Reference No:	2025/62/93559/E
Site Address:	The Acres, 9, Greenfield Close, Upper Denby, Huddersfield, HD8 8UT
Description:	Use of land for siting of a camping pod
Recommending Officer:	Kerri Simpson

DECISION – CONDITIONAL FULL PERMISSION

Officer Report – 2025/93559

DRAWING TITLE
GA DRAWING - PROPOSED CAMPING POD

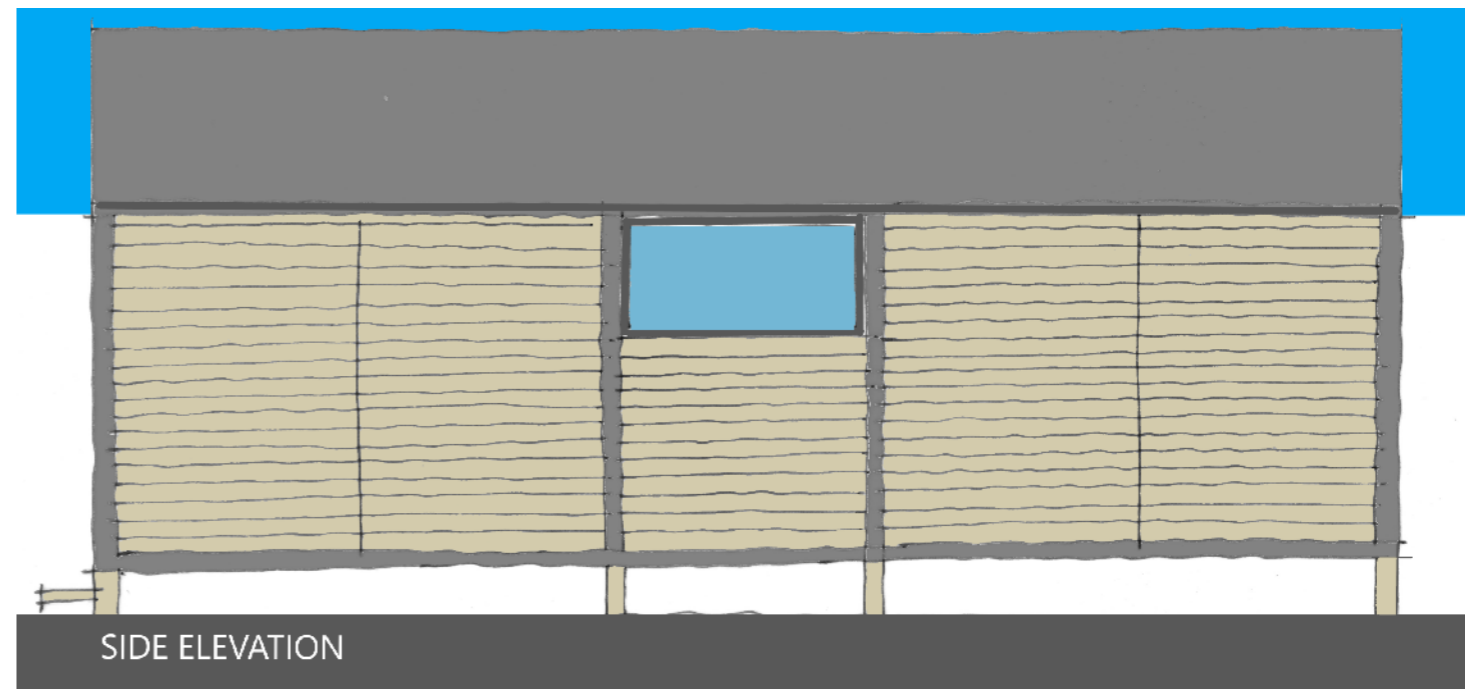
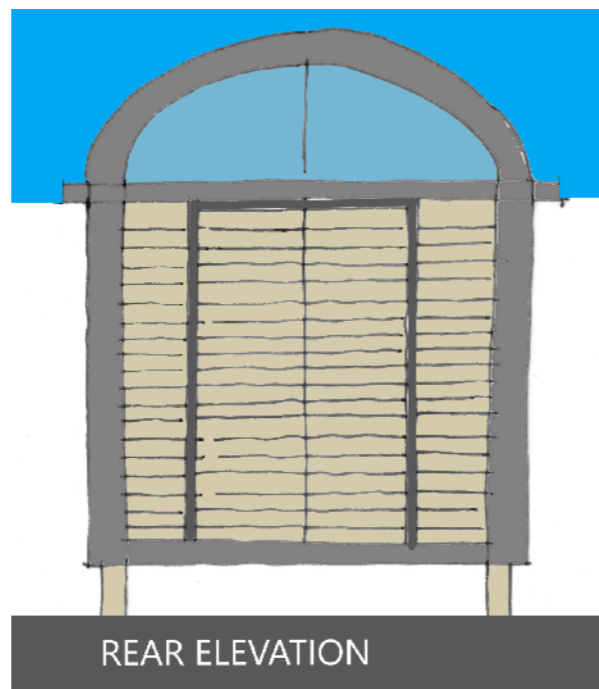
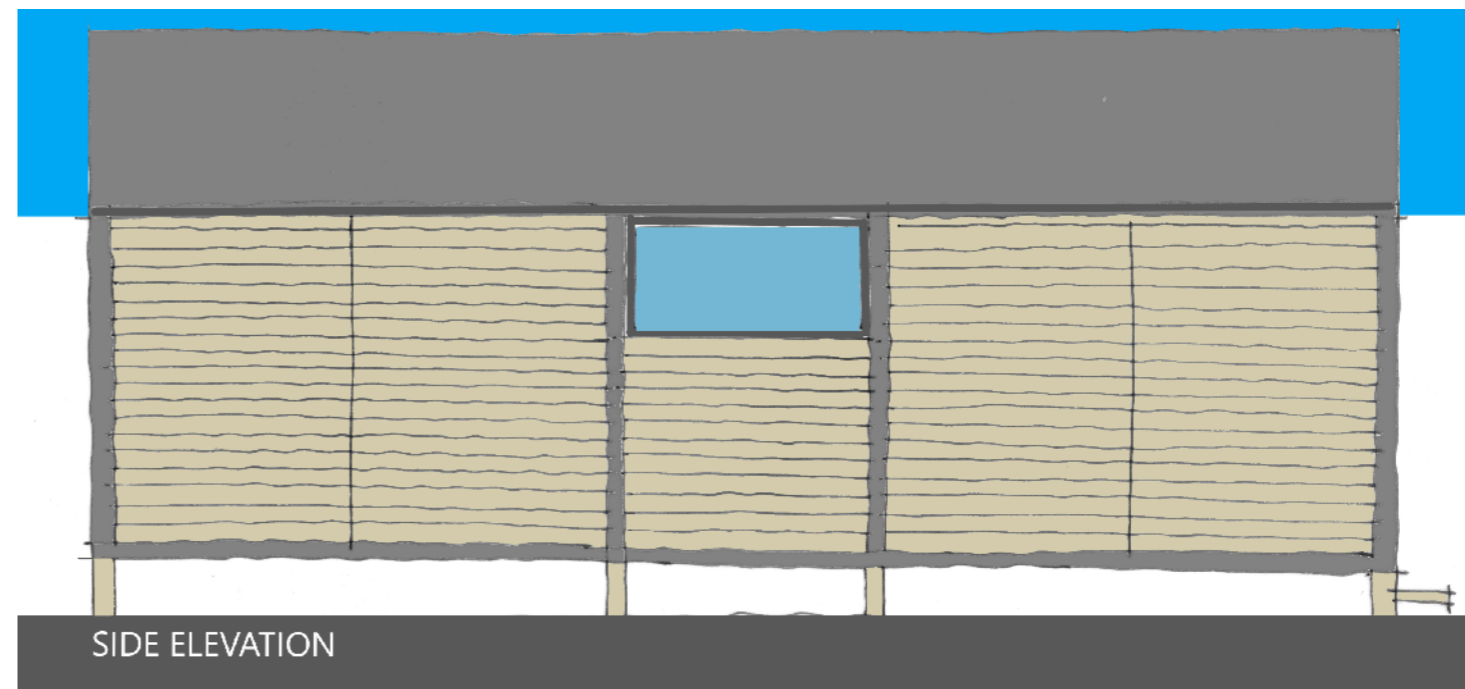
The application site comprises part of an existing domestic garden positioned within the Green Belt. It is enclosed by mature trees and vegetation along much of its northern, eastern, and western boundaries. The proposal comprises a single camping pod of modest scale measuring circa 30sqm, with a maximum height of around 3.9m. The building would be finished in timber boarding reflecting a utilitarian design commonly associated with rural

The pod would be positioned towards the southern part of the site where it would benefit from the screening afforded by existing mature vegetation and would be viewed against the backdrop of existing trees. Whilst the proposal would introduce built form into an area currently comprising garden land, its limited scale, simple design and sitting would ensure it does not appear visually dominant or incongruous within the wider landscape.

3. The external walls of the development hereby approved shall be constructed from horizontal timber cladding, the roofs using composite profiled panels of a black colour finish and the windows and door frames using timber. These materials shall thereafter be retained.
Reason: In the interests of protecting visual amenity and the character of the Green Belt in accordance with Policies LP24 and LP56 of the Kirklees Local Plan and Chapters 12 and 13 of the National Planning Policy Framework.

CLIENT <b>MR &amp; MRS A MARWOOD</b>		DRAWING TITLE <b>BLOCK PLAN - PROPOSED</b>			
PROJECT <b>THE ACRES, 9 GREENFIELD CLOSE, UPPER DENBY, HUDDERSFIELD, HD8 8UT</b>	JOB NO <b>WHPR 25-0095</b>	DRG NO <b>03</b>	REV <b>A</b>	SCALE @ A3 <b>1:200</b>	DATE <b>17 12 25</b>

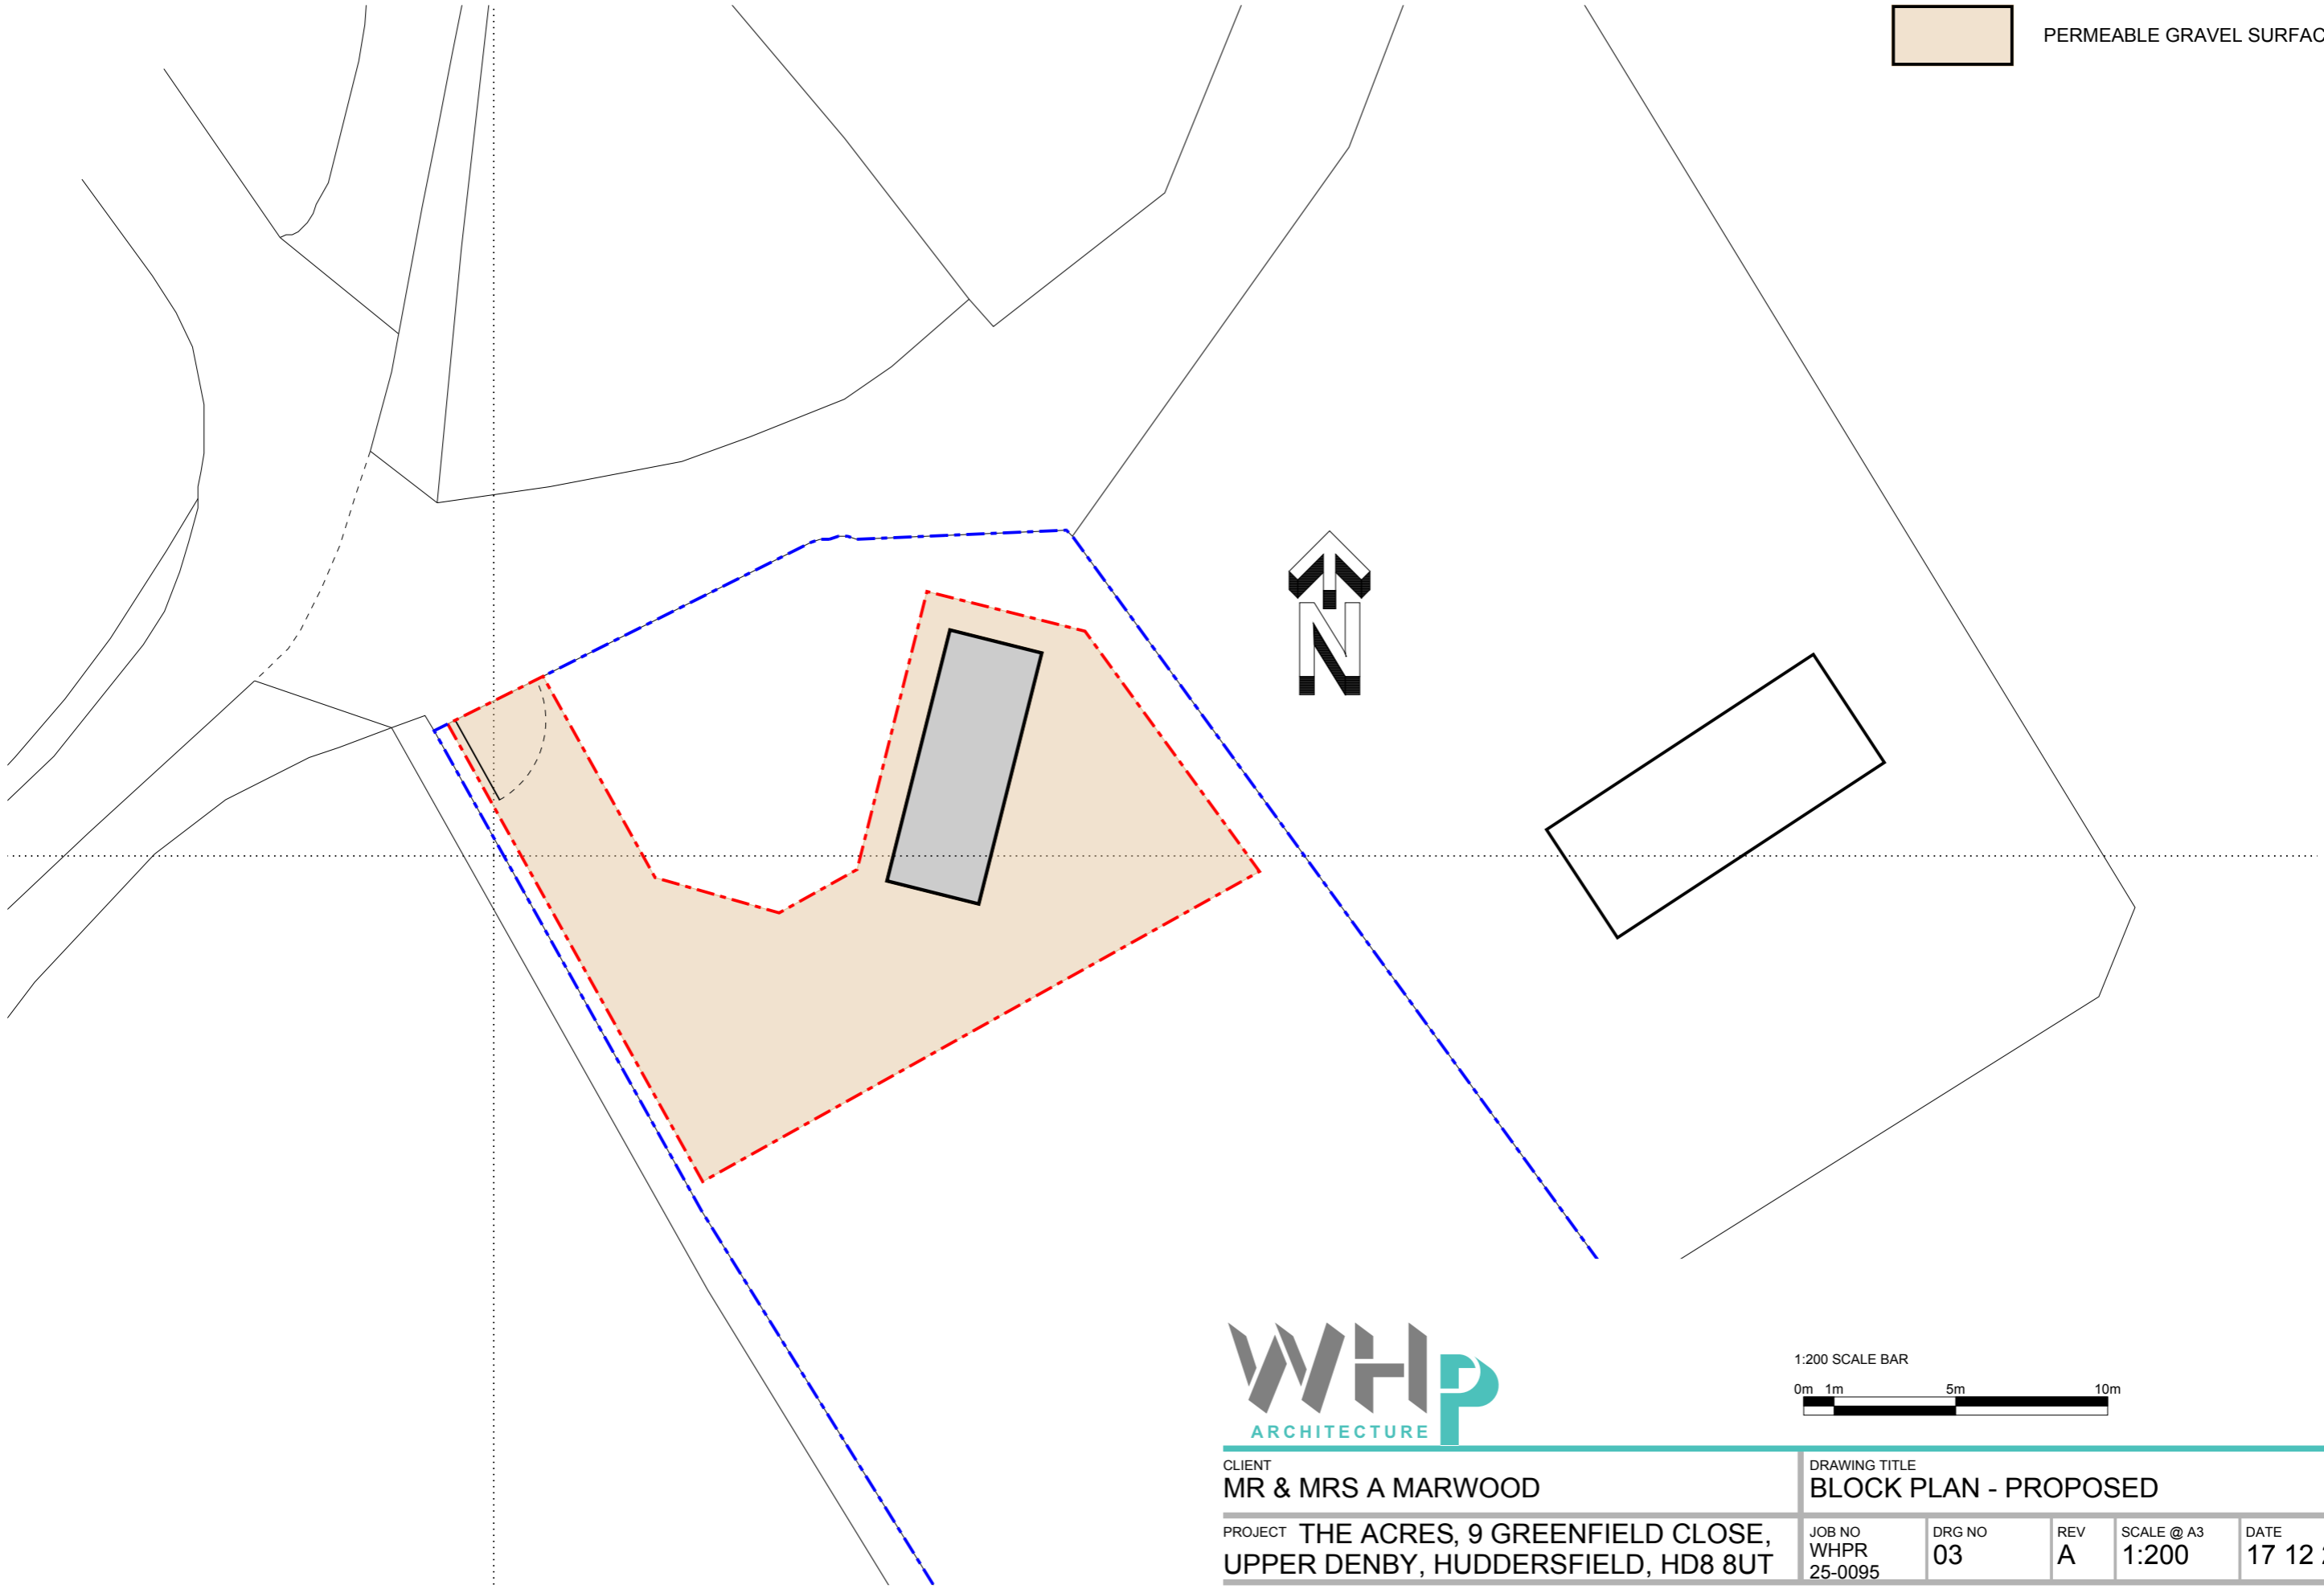
The proposal also includes a gravel parking area and passing places on Bank Lane. Such features are relatively commonplace within rural areas and, given their limited extent and informal surfacing, are not considered to materially urbanise the character of the locality.

A condition is recommended requiring the parking area to be laid out and made available prior to the first occupation of the development and thereafter retained for its intended purpose. In addition, a condition requiring the submission and approval of details of refuse storage/collection arrangements prior to the first occupation of the development is considered necessary to ensure the development can operate satisfactorily and independent of the host dwelling at No.9 Greenfield Close.

6. The camping pod hereby approved shall not be brought into use until all areas to be hard surfaced for access and parking have been and out with a hardened and drained surface in accordance with the

DRAWING TITLE
ACCESS ROAD PLAN

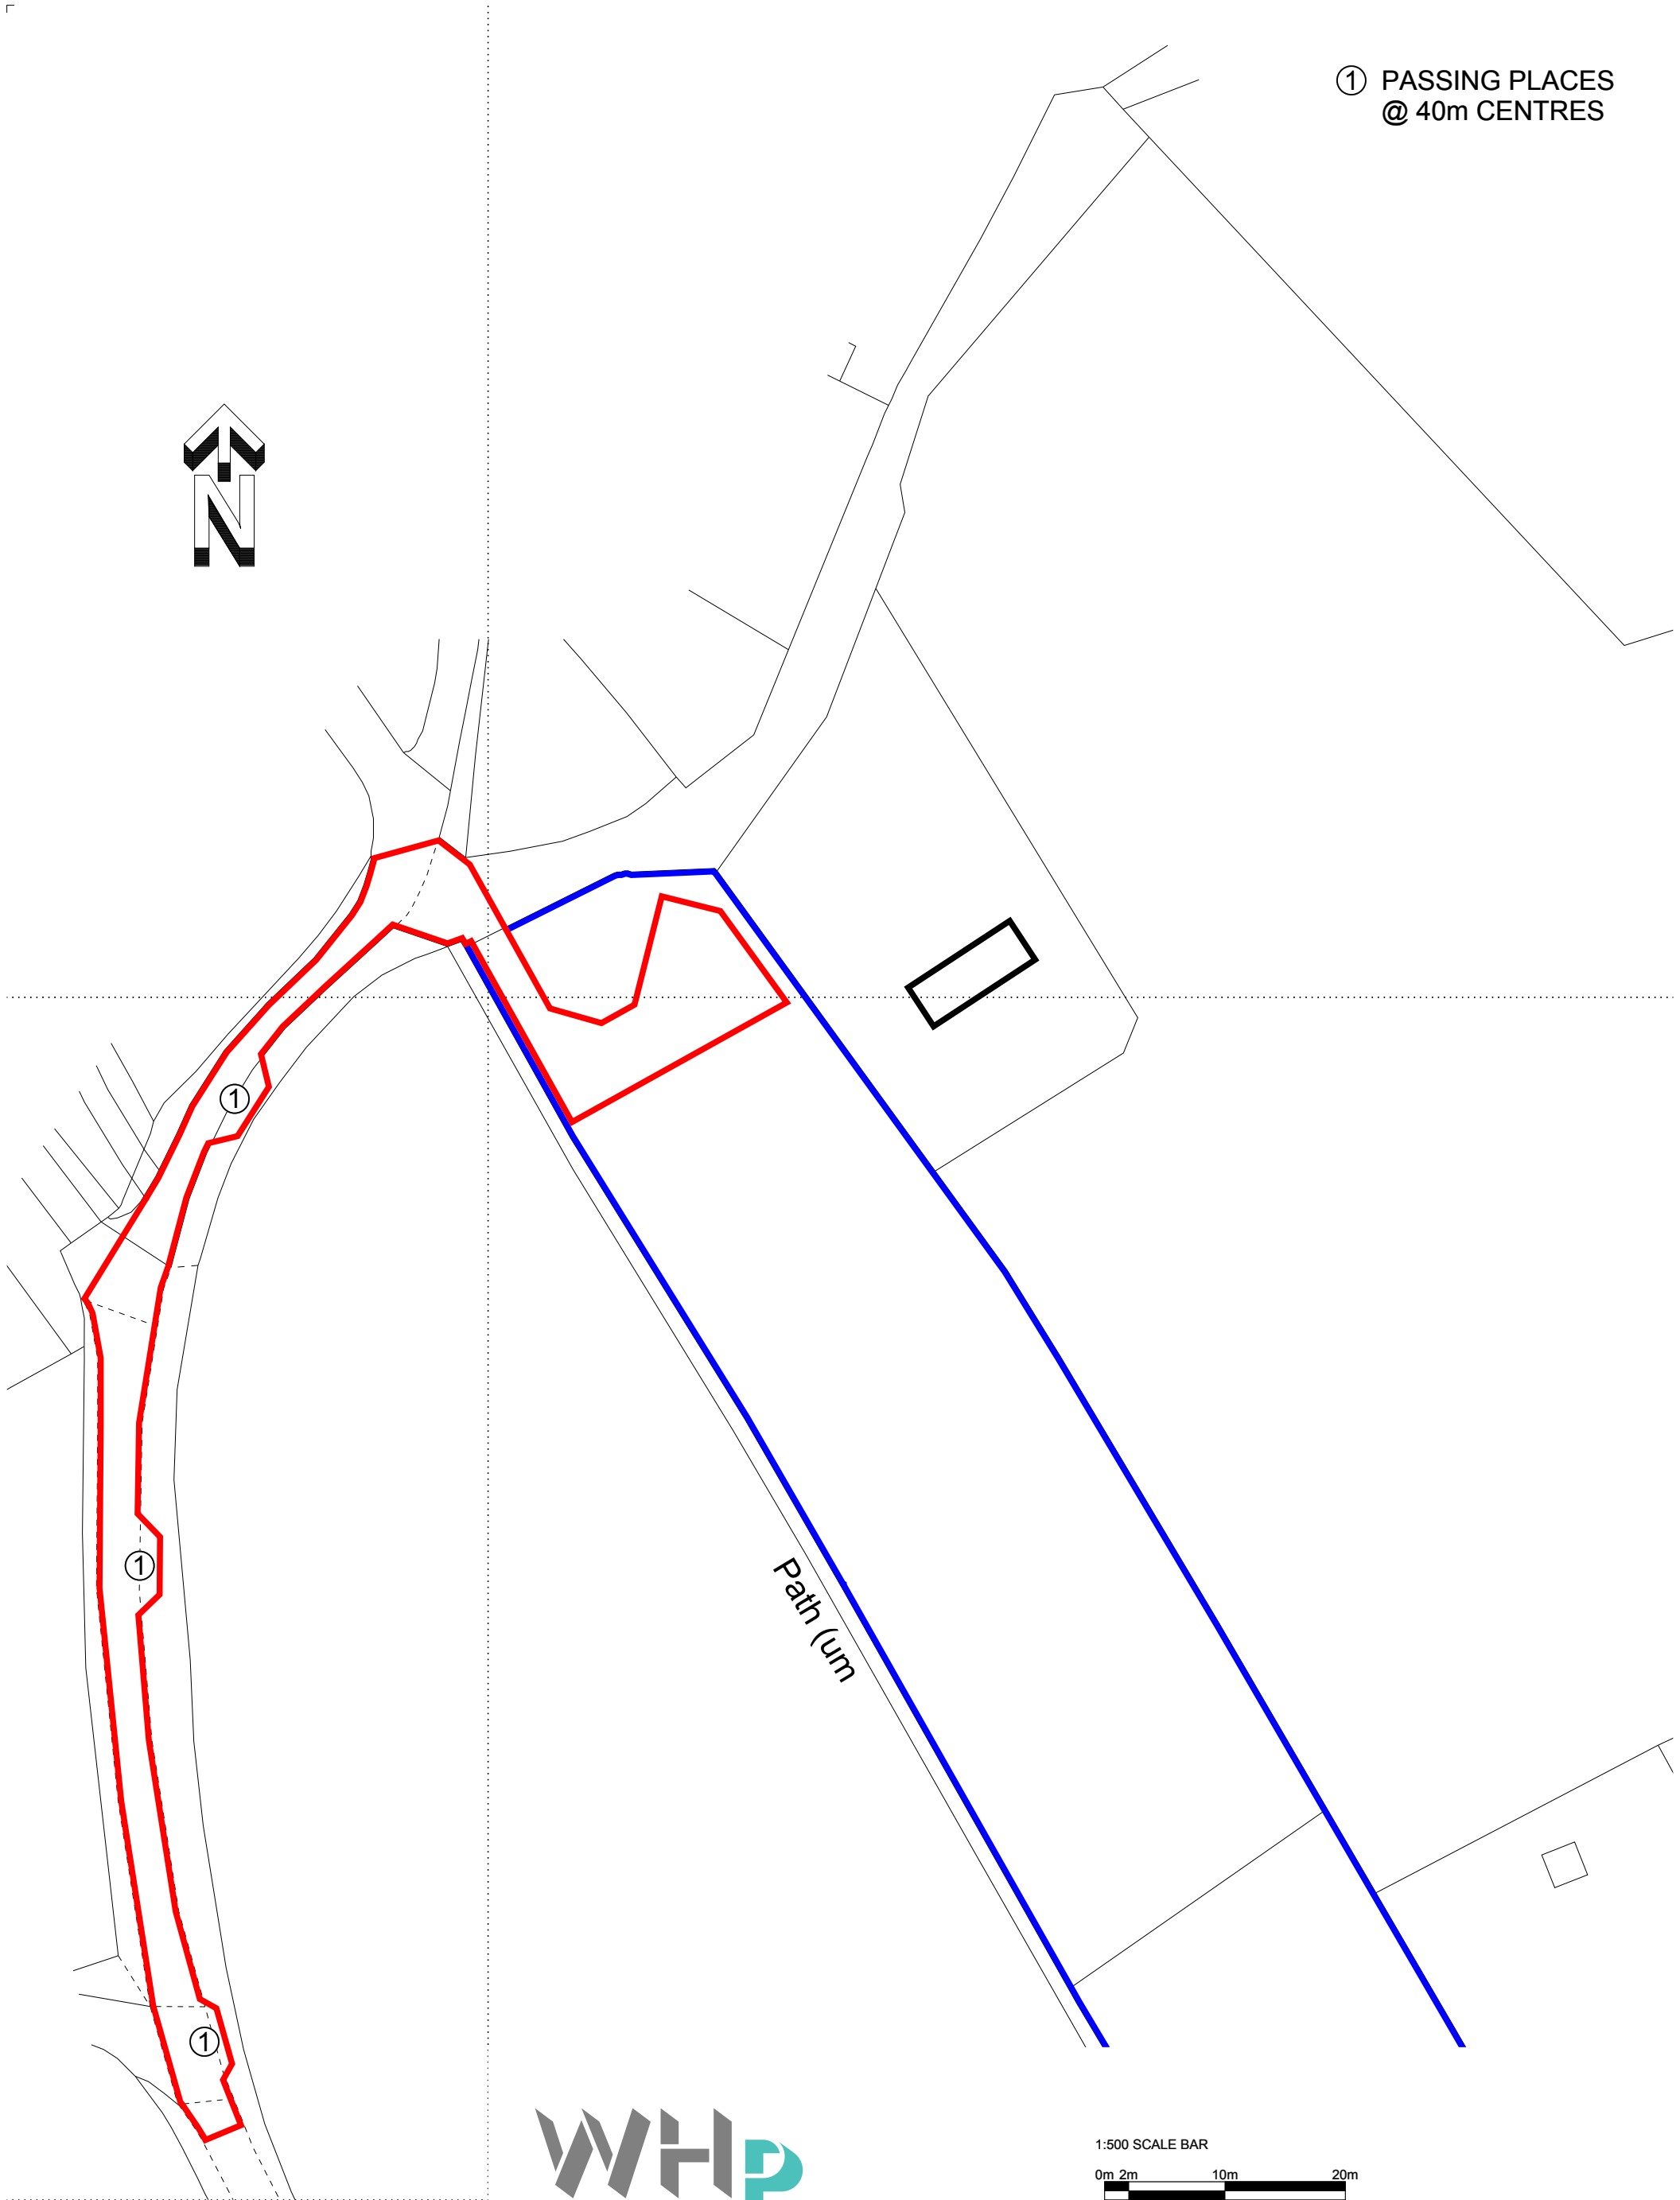
It is acknowledged that planning permission 2020/93619 for four camping pods on neighbouring land also proposed access from Bank Lane. AS part of that permission, the Highways Development Management Team required the provision of passing places along the final section of the unadopted lane, together with details of their construction, surfacing and drainage, in the interests of highway safety.

Whilst this current proposal on this site, would be limited to a single camping pod and would not, in isolation, generate a significant increase in traffic movements, it would utilise the same section of Bank Lane which functions as a Bridleway before connecting with a wider network of Public Rights of Way adjacent to the site. Given the shared use of this route by vehicles, pedestrians, cyclists, and horse riders, it is considered reasonable and necessary, in the interests of highway safety, to impose conditions requiring the implementation of the proposed passing places and associated access works prior to the first occupation of the development.

It is therefore considered reasonable and necessary, in the interests of highway safety to impose conditions requiring the submission and implementation of the passing places and associated access works prior to the first occupation of the development.

7. Prior to the first occupation of the development hereby approved, the vehicle passing places shown on approved drawing no. 04, titled Access Road Plan, dated 13/07/2026 shall be laid out and made available for use. The passing places shall thereafter be retained for the lifetime of the development. **Reason:** In the interests of highway safety and to accord with Policies LP21 and LP24 of the Kirklees Local Plan, the Highway Design Guide SPD and Chapter 9 of the National Planning Policy Framework 2024.
